**Response to EIS – Atlassian Office and Hostel Development – SSD 10405**

Thank you for your correspondence dated 10 December 2020 seeking comment on the EIS for the Atlassian office and YHA hostel development at 8-10 Lee Street, Haymarket. City staff have reviewed the EIS and provide the following feedback.

**Pedestrian Wind Safety Conditions - Ground Floor**  
 Configuration 4: Proposed Development, Dexu/ Fraser and Toga with Existing Surrounding Buildings  
 Annual

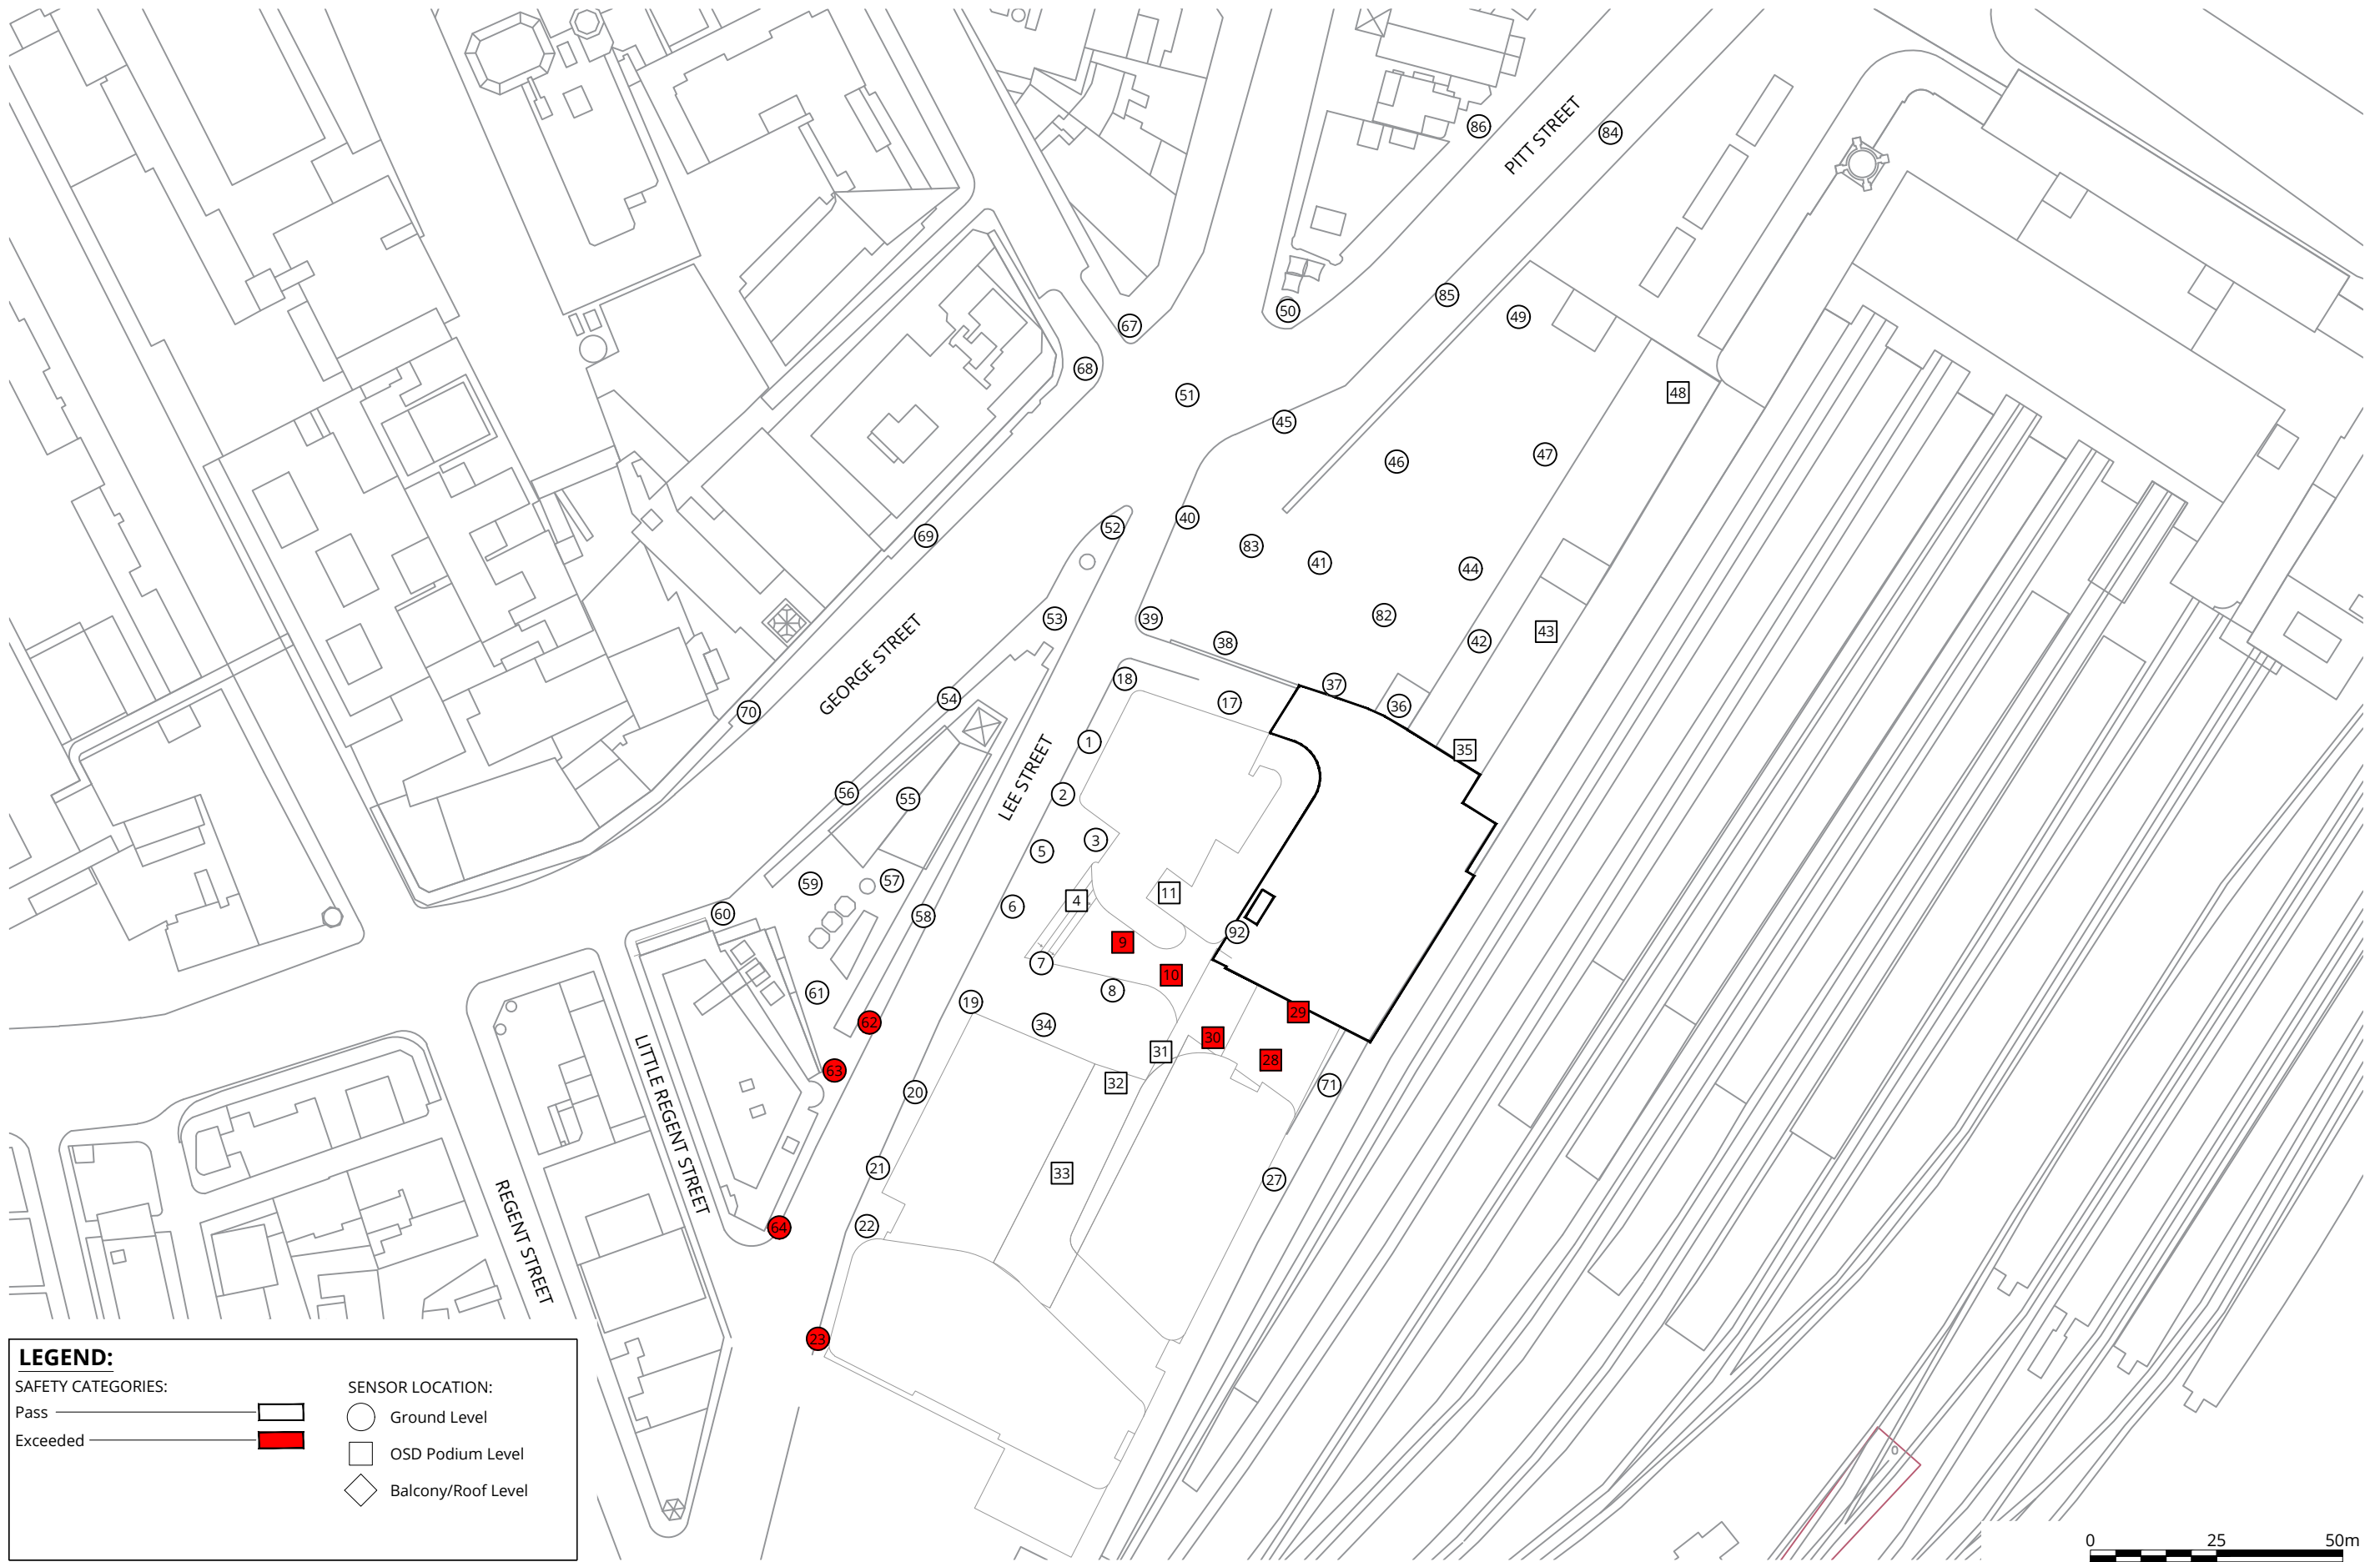
14. The Design Guidelines includes the following requirement at part 3.1.5 (3): *Wind impacts from any development must not exceed the Wind Safety Standard which is an annual maximum peak 0.5 second gust wind speed in 1 hour of 24m/s*. The wind report notes that in the scenario with only the Atlassian project constructed, the safety standard is exceeded at 11 locations.

15. One location (23) is disregarded as it is a function of the existing context. Under the Atlassian + Dexus/Frasers development scenario, the safety standard is exceeded at 14 locations. Under the Atlassian + Dexus/Frasers + Toga development scenario, the safety standard is exceeded at 13 locations. In all scenarios, a number of the safety exceedances occur on the 'bleachers', and in the Atlassian only scenario, additional exceedance occurs at the Upper Ground Level Plan, where outdoor sitting areas are planned. The proposal clearly does not comply with the Design Guidelines objectives for Wind in part 3.1.5, which are:

**PROPOSED STORMWATER
CONCEPT PLAN**

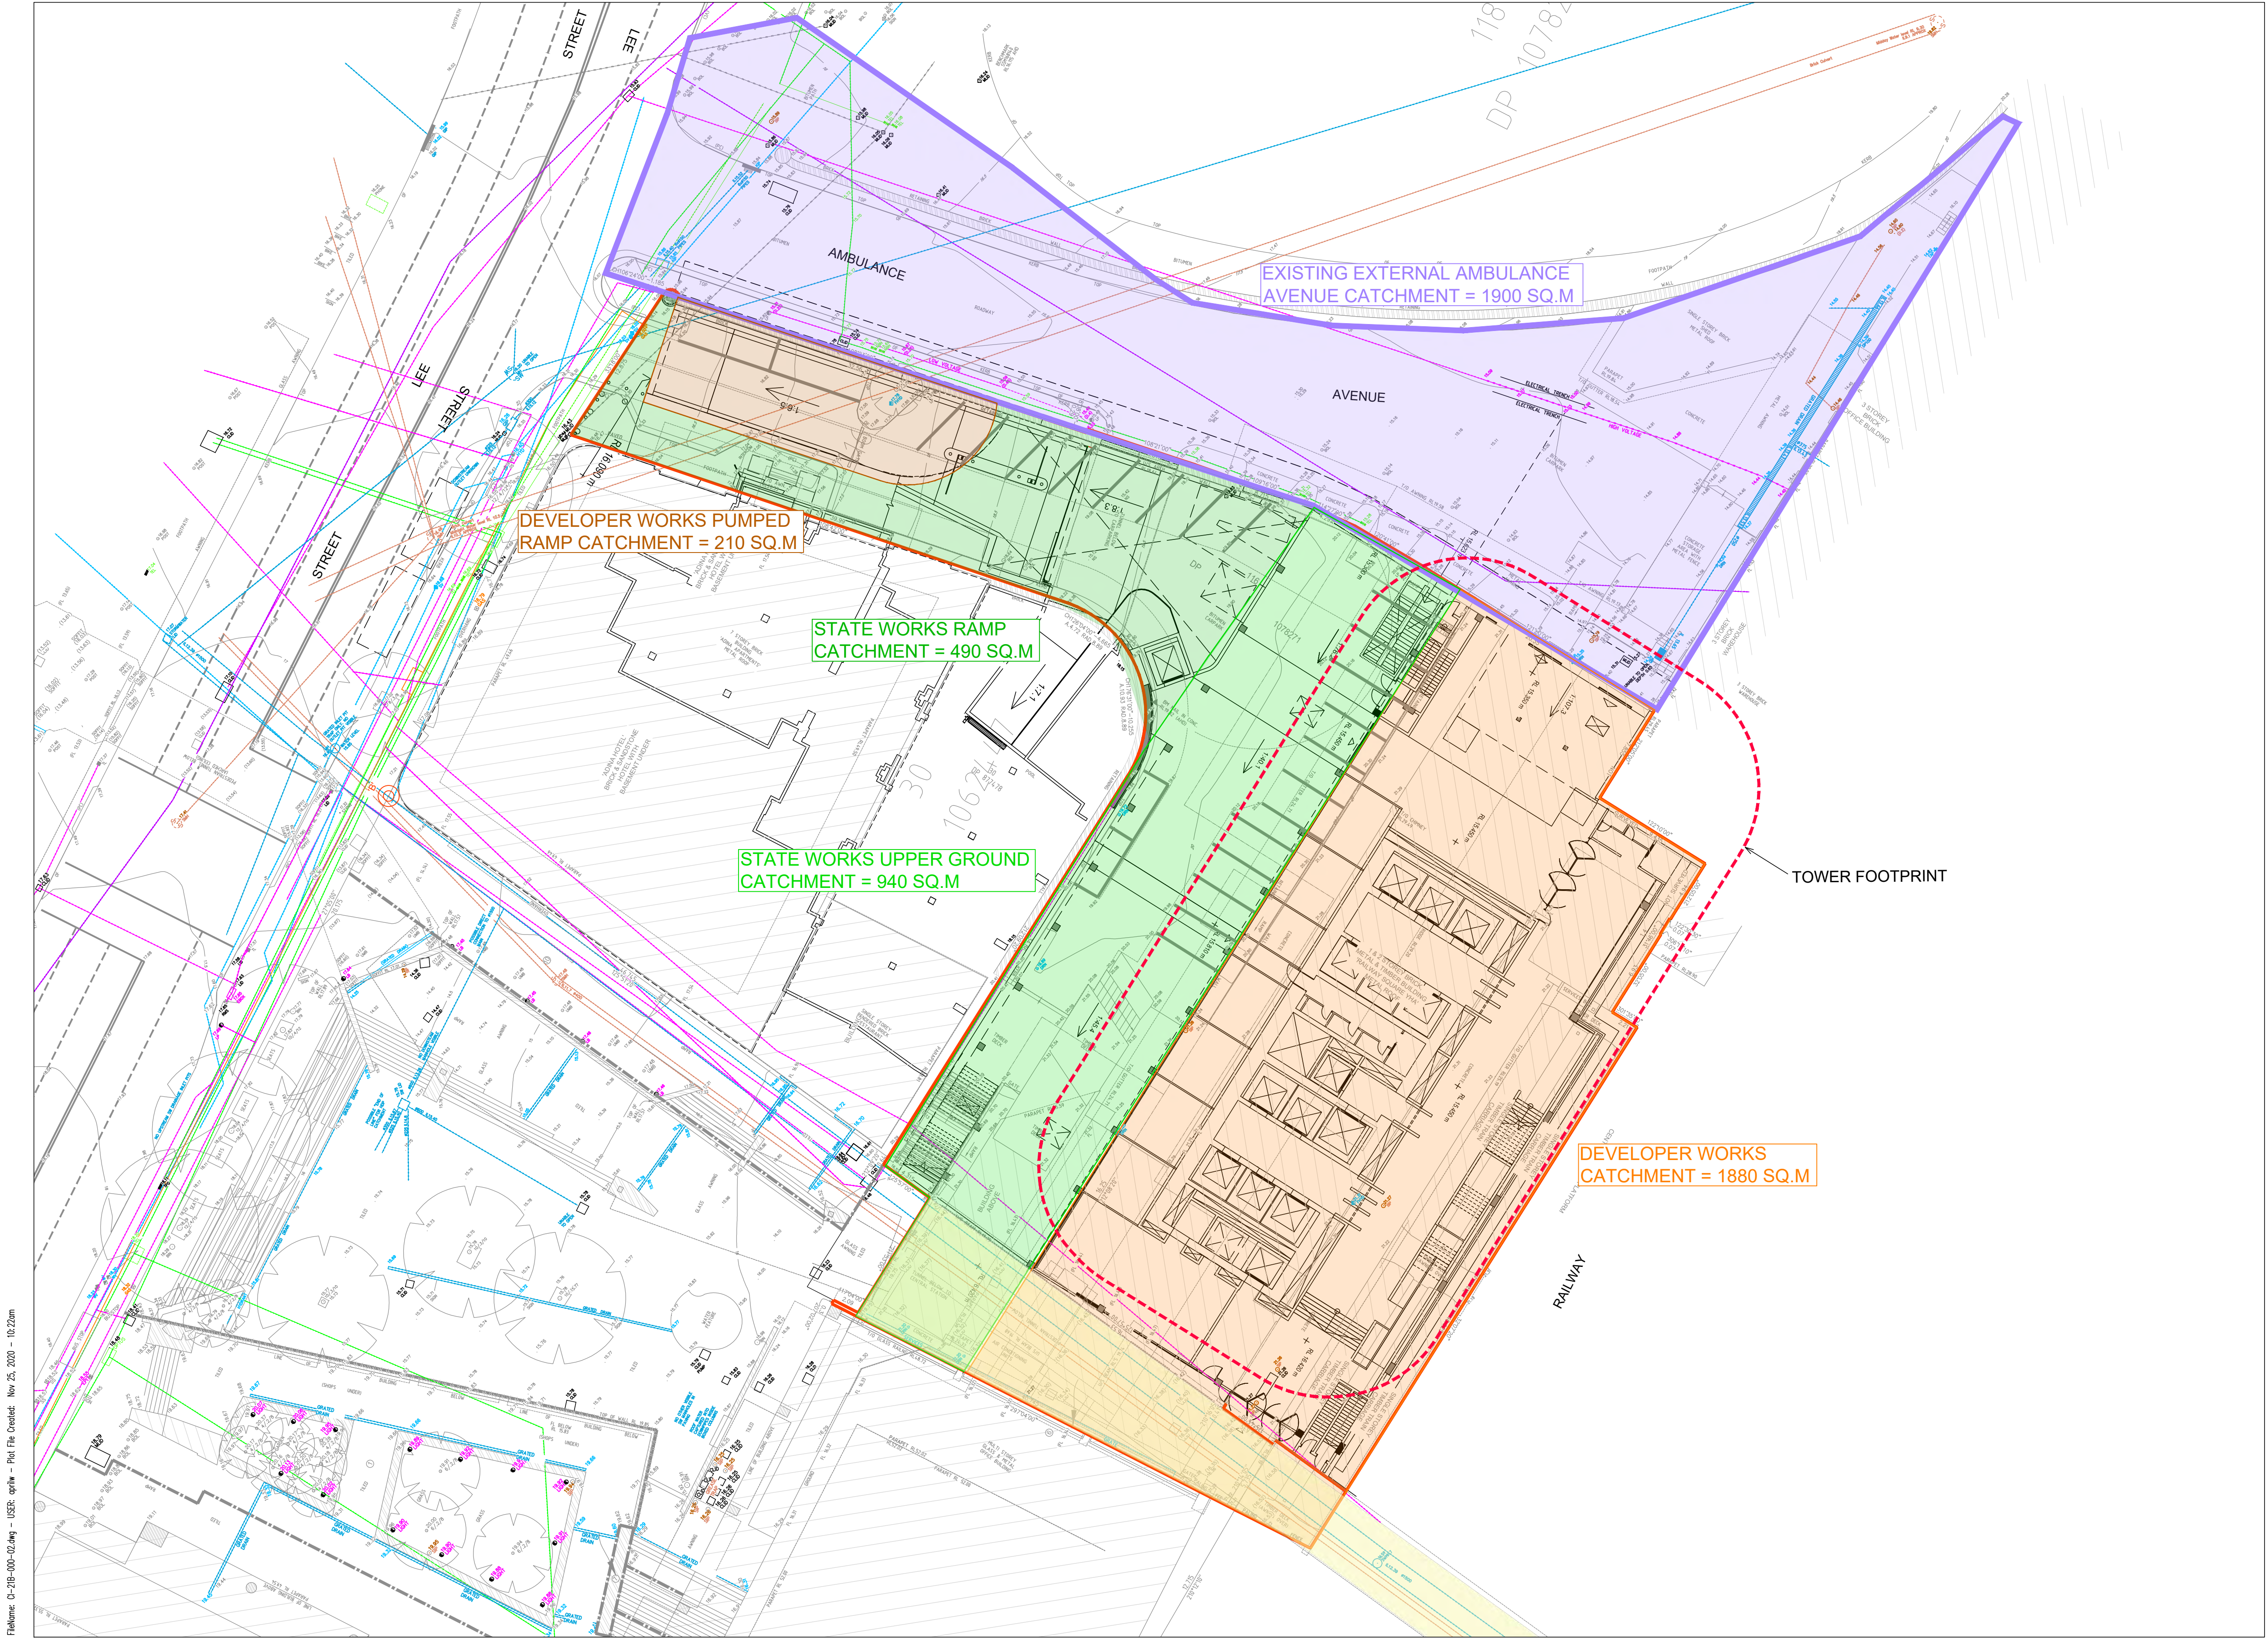
43. The City is concerned that the development is relying on a proposed stormwater network extension to reduce flood levels in Ambulance Avenue, which is unacceptable. All flood planning levels are to comply with the City's [Interim Floodplain Management Policy](#). The following further information should be submitted for review prior to determination:

- a. A study regarding the practicability and constructability of the proposed stormwater network extension, regarding underground utilities in the area.

- b. Approval from Sydney Water for the proposed extension to connect to the Sydney Water trunk drain.
  - c. Failsafe design of the inlet structures in the Ambulance Avenue sag, for example blockage of the inlets.
